Revised Owners manual v 1.16 recommendation for shaft assembly

Description of Issue: Mariah Power recommends performing the following steps for shaft assembly for improved functionality of the Windspire.

Note: This revision applies to step 22, page 44 of version 1.16 of the Windspire Owners manual. This revision is applicable for new installations.

Figure 2-59: Positioning the Top-Shaft Clamp

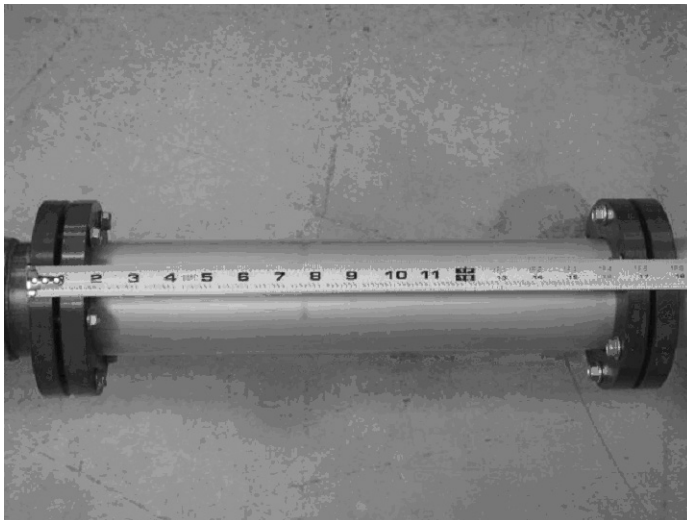
1. At the time of assembly, liberally apply copper or aluminum based anti-seize compound to the top 3 to 4 inches of the bottom shaft.
2. The location of the upper top shaft clamp should be changed from 18 in. to 12 in. above the lower clamp.
3. In addition, if the top clamp is removed after unit has been in operation, on reassembly the clamp should be positioned $\frac{1}{4}$ " above the previous location. (This only applies to new installations, for clamps positioned as described in this bulletin).
4. Touch up any place where the paint has been worn through and exposed bare metal to prevent rusting.
